OXFORDSHIRE COUNTY COUNCIL'S RESPONSE TO CONSULTATION ON THE FOLLOWING DEVELOPMENT PROPOSAL

Application no: 21/04171/F

Proposal: Re-development of part of existing car park to provide a drive-thru cafe within Use Class E; together with associated car parking, servicing and access; landscaping and all associated works

Location: Jacobs Douwe Edberts, Ruscote Avenue, Banbury

(03)-S3-S-002

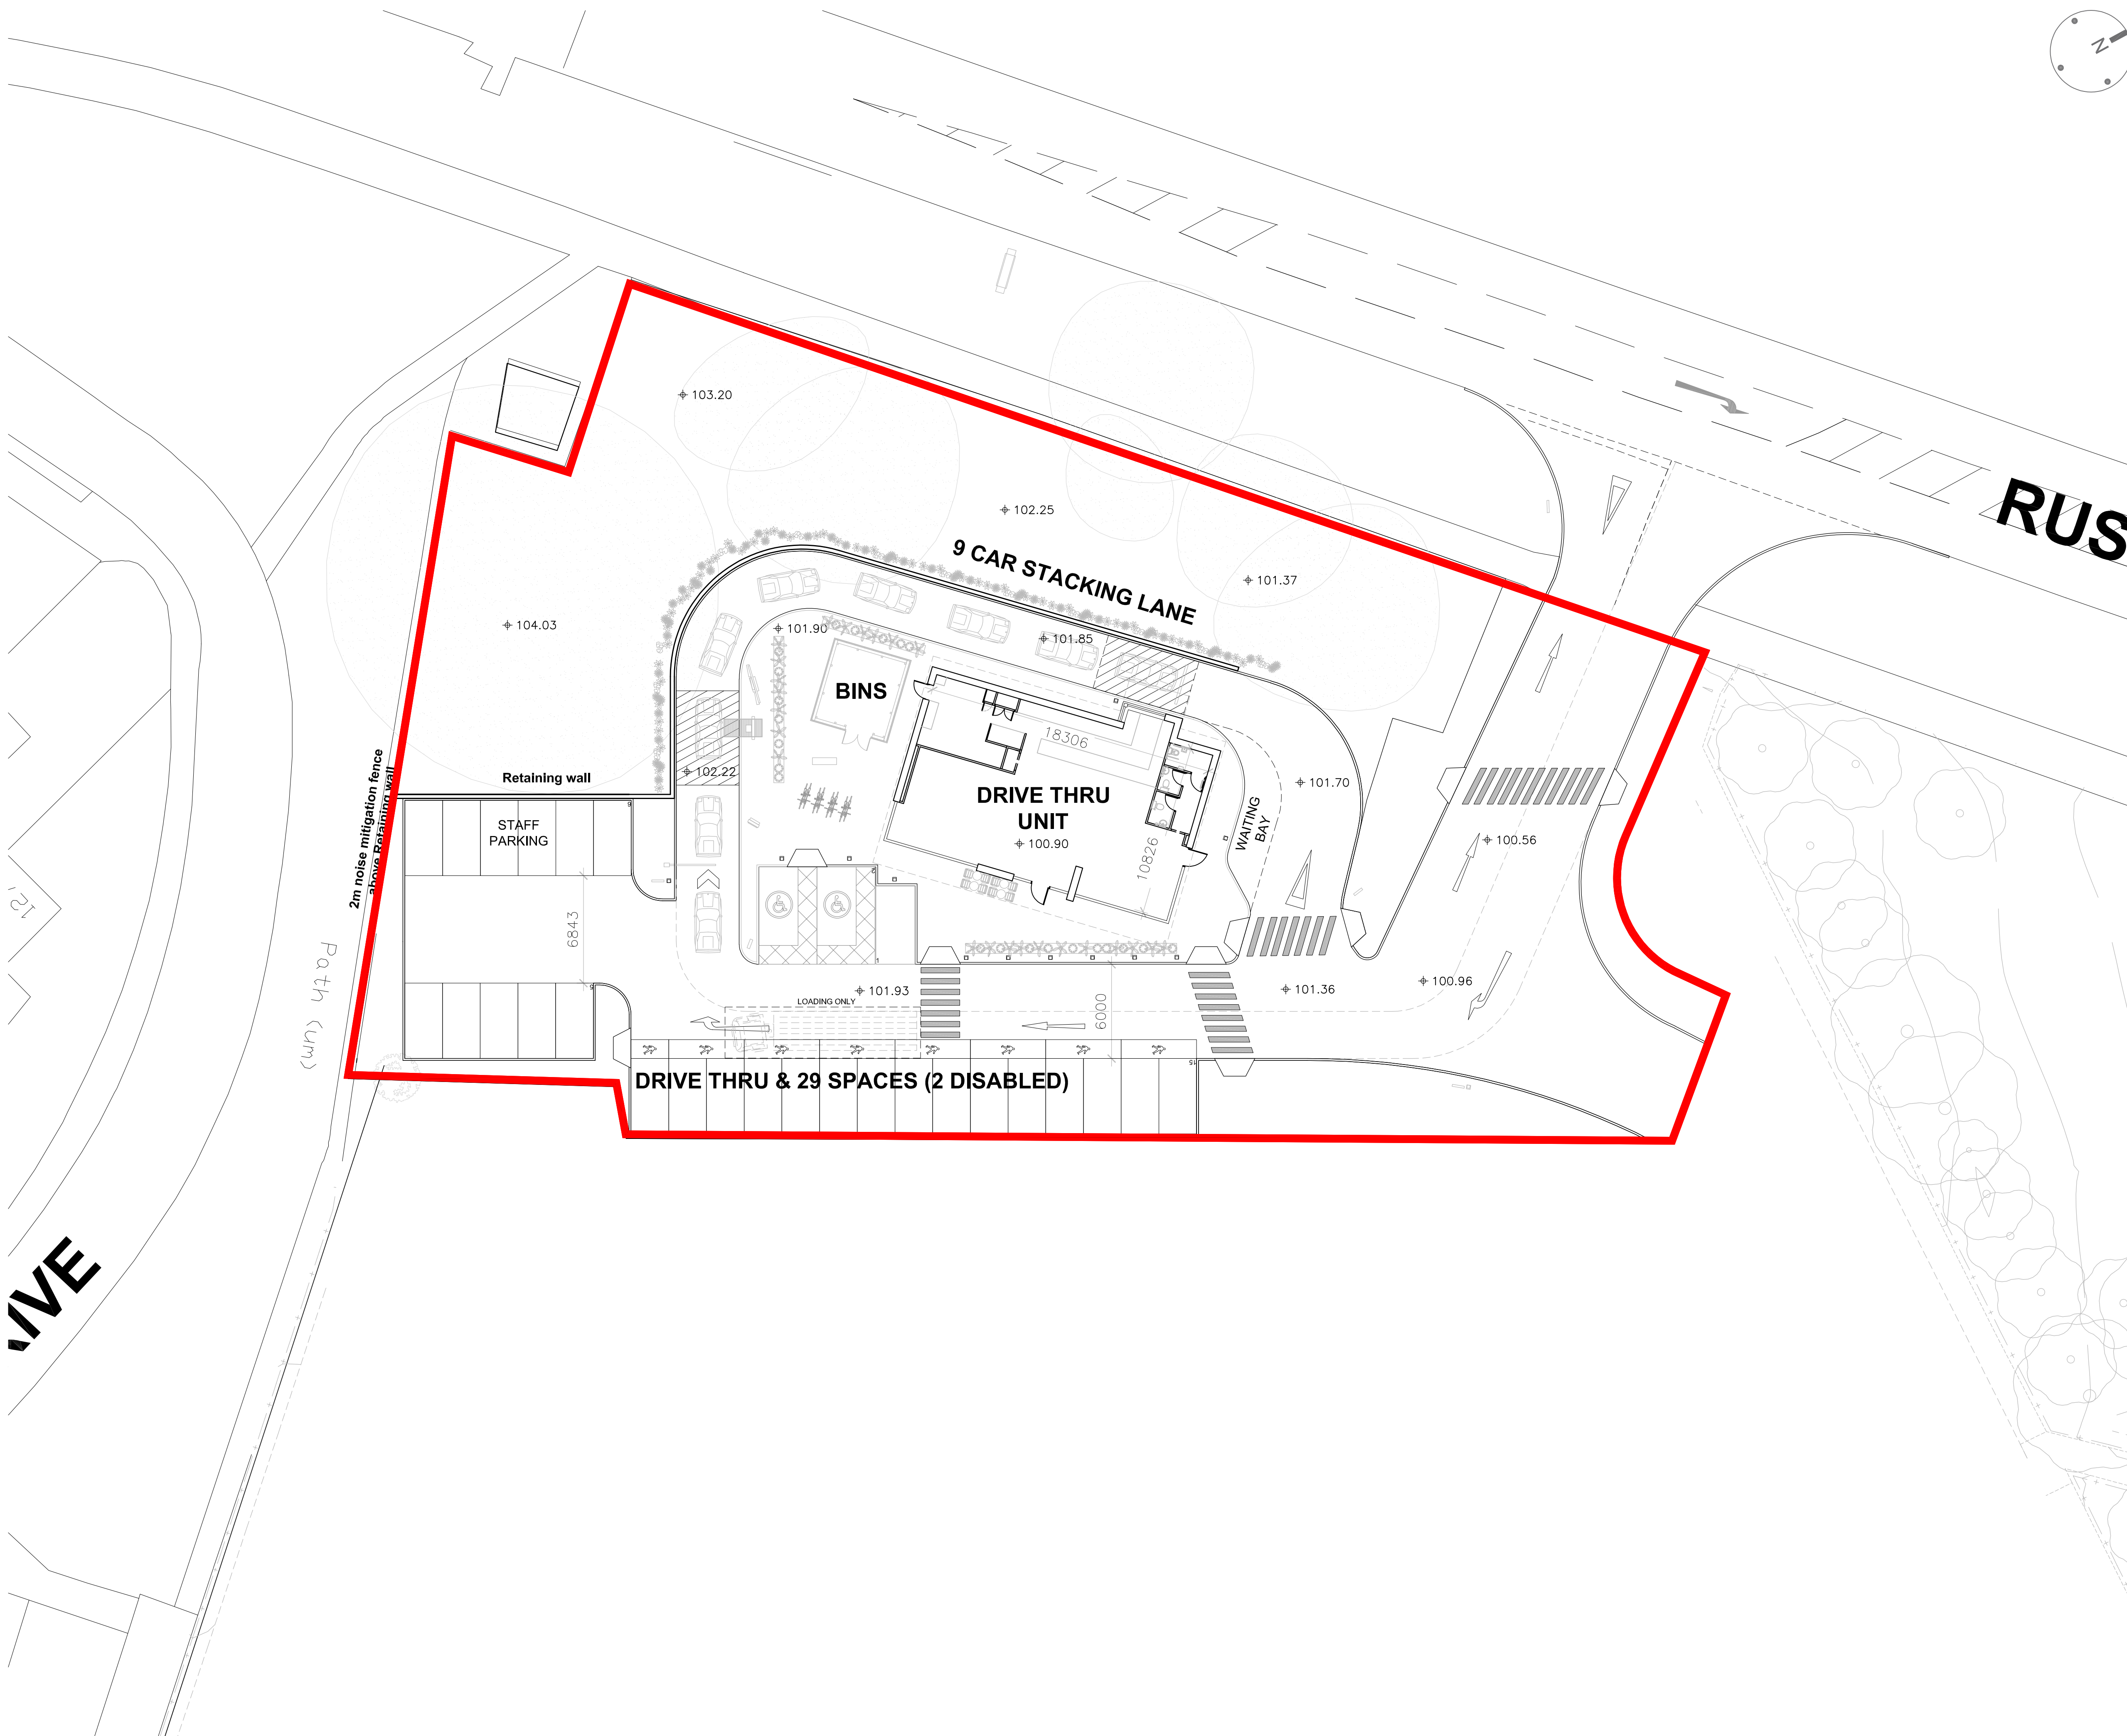
The Design and Access Statement states that 'covered bicycle shelters will be provided on site to encourage more sustainable transport and to provide secure, more easily accessible storage for bikes'. That is however not the case as the proposed site plan (Drwg No: (03)-S3-S-002 Rev PL5) illustrates otherwise.

There appears to be a potential conflict point where drivers may not know who has right of way. The layout needs to make it clear possibly by give-way markings to allow vehicles from parking spaces further south to exit with priority over those heading into the drive-thru. See illustration below.

I am left concerned that such an arrangement may lead to arriving vehicles backing back onto Ruscite Avenue which has not been carefully considered.

The delivery and waste collection arrangements illustrated in the drawing referenced above has not given thoughtful consideration to safety and continued use of vehicles into the drive-thru. Without a designated area for the lorries associated with deliveries and refuse, these vehicles shall (for the duration of their operation) compromise the following:

- Block the arrival lane which could have potential tail backs to the site access and Ruscite Avenue;
- Whilst doing so, there is a risk of blocking in about 6 vehicles within their parking bays to the east of the development.
- The walk way that would lead pedestrians to a safe crossing would also be compromised leaving them (pedestrians) to walk into conflict where the only available lane shall be used by both incoming and exiting vehicles.
- cars parked further south would
